**Consultation Response from: KC Environmental Health (Pollution & Noise Control)**
**2026/90783 7 Wakefield Road, Grange Moor, Huddersfield, WF4 4DS**
**Erection of extension and refurbishments to former petrol filling station/car sales to form petrol filling station with retail, office, hot food take-away, car sales and repair facilities with canopy, car wash area, PF pumps, parking and storage tanks**
**Responding Date:**  
29<sup>th</sup> April 2026

**Responding Ref:**  
WK202611836

Site Plan
1 : 200

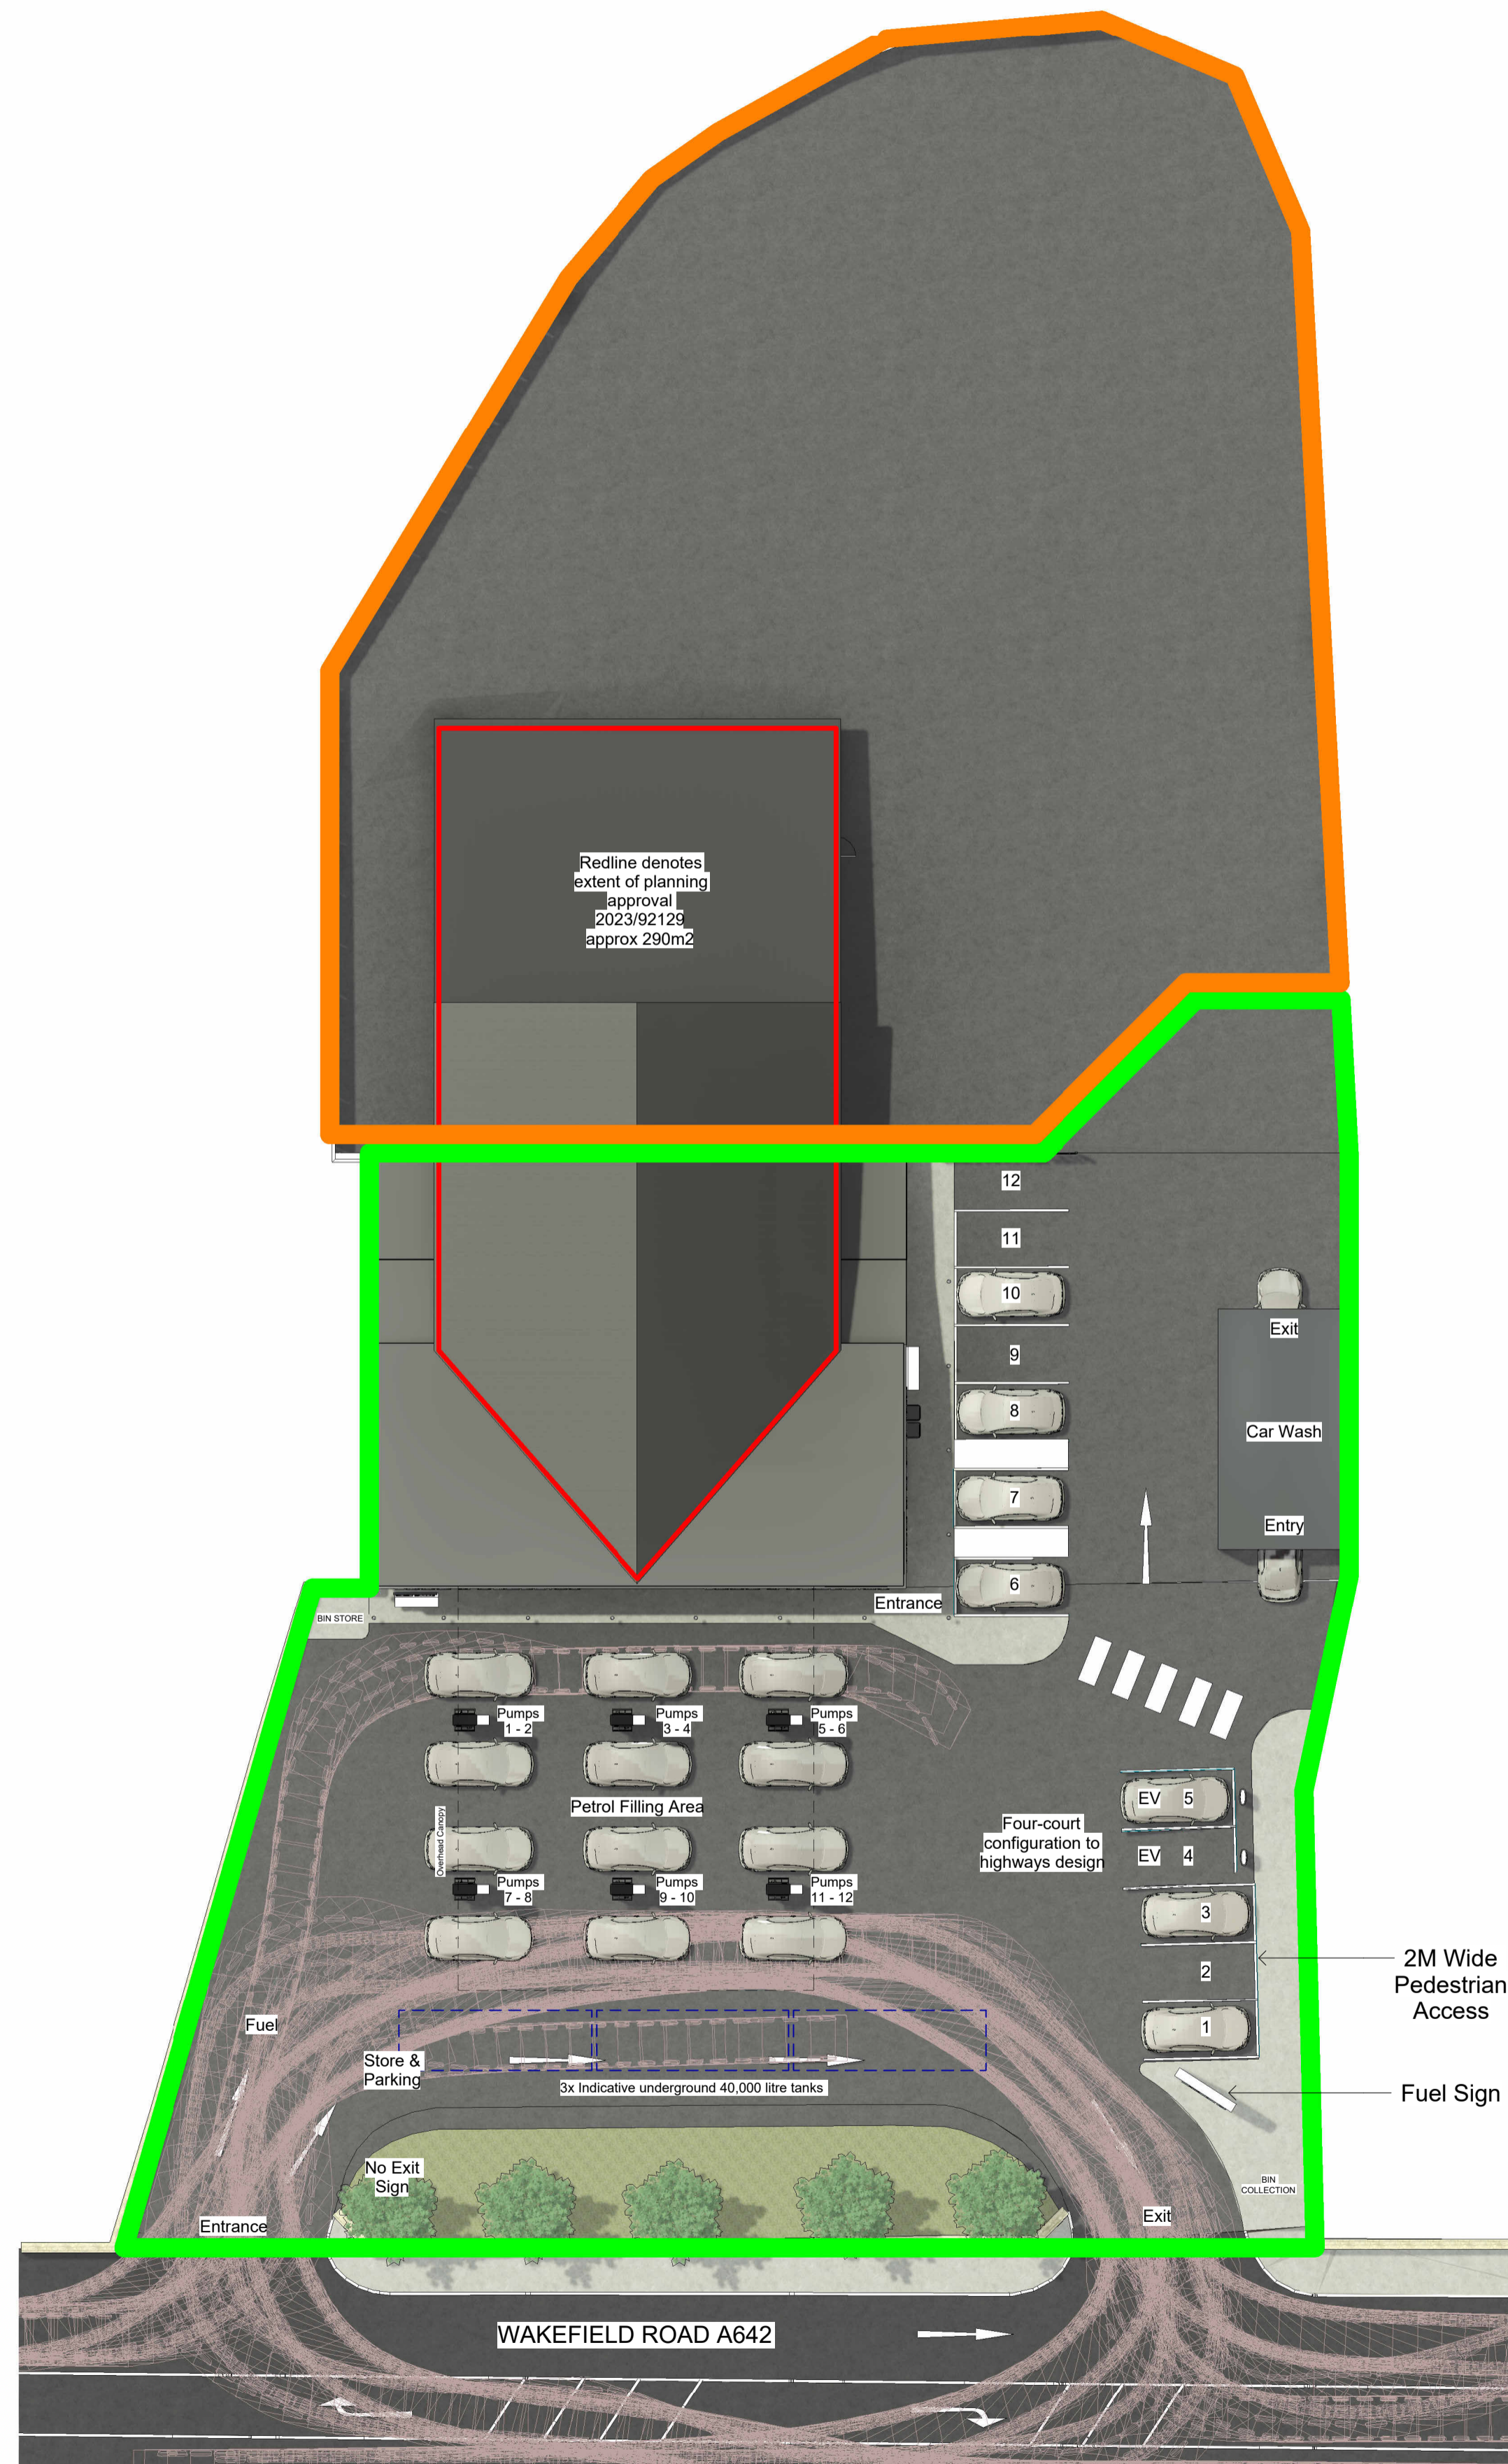
The proposed development is not situated in an Air Quality Management Area and whilst it is on a busy A road it is not identified on our mapping as an area of concern. Looking at the proposal and plans we cannot see provision for electric vehicle charging points (EVCP'S), In an application of this nature, it is expected that facilities for charging electric vehicles and other ultra-low emission vehicles are provided in accordance with the National Planning Policy Framework and *Air Quality & Emissions Technical Planning Guidance* from the West Yorkshire Low Emissions Strategy Group. We therefore recommend a condition.

Before first occupation, a scheme outlining the specific facilities for charging electric vehicles and other ultra-low emission vehicles for parking spaces at the development must be submitted to and approved in writing by the Local Planning Authority. This scheme must meet the minimum requirements in the current West Yorkshire Low Emission Strategy (WYLES) document; currently 10% of parking spaces. The approved facilities for charging electric vehicles must be installed before occupation and retained for use thereafter.
